**CHARLOTTE - MECKLENBURG**  
**PLANNING COMMISSION**

**INTER - OFFICE COMMUNICATION**

**SUBJECT:** Administrative Approval for Petition No. 97-43 by William Putnam Ross, r. Marion Ross, Jr.,  
Robbie G. Ross.

Technical Data Sheet
Petition # 97-43

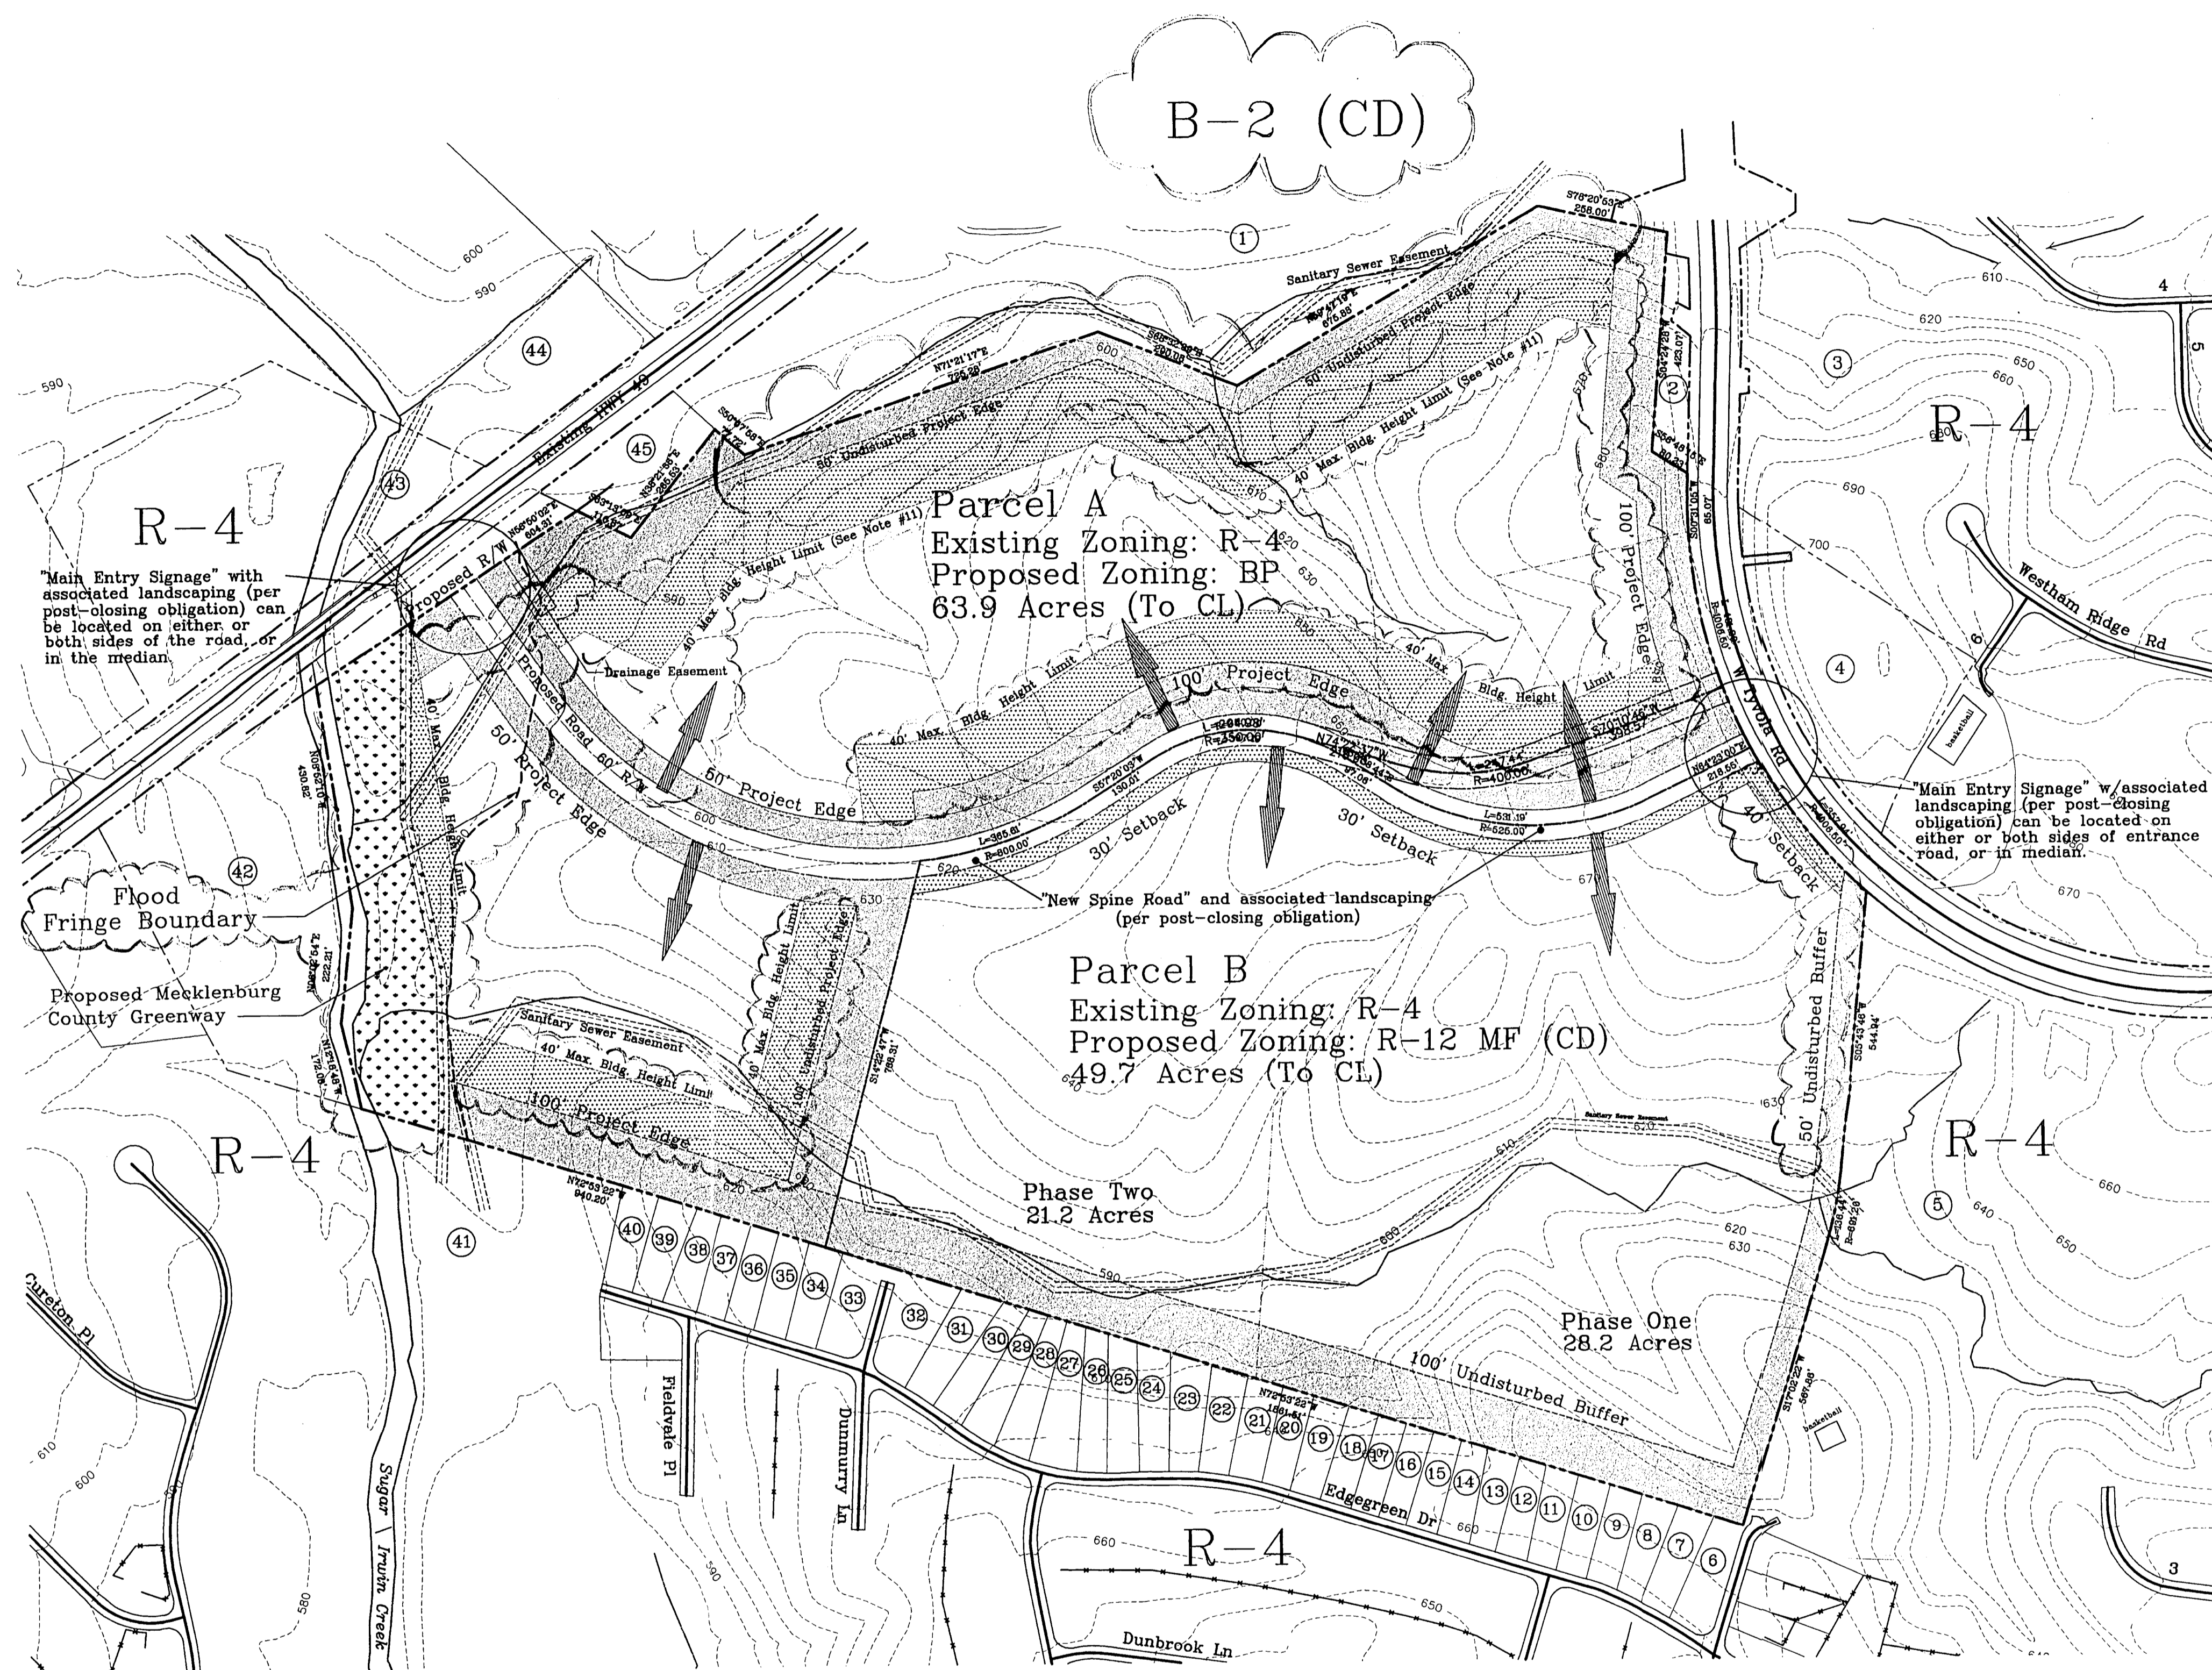
Attached is the revised technical data sheet for the above petition. The plan has been revised to allow dedication of the greenway prior to the issuance of a certificate of occupancy for the first building adjoining this greenway and to reduce the project edge along the northern property line to 50-feet. Since these changes do not alter the intent of the development and meet the requirements of the Charlotte Zoning Ordinance Section 6.206(2) Alterations to Approval for minor changes, I am administratively approving this plan. Please use this plan when evaluating requests for building permits and certificates of occupancy.
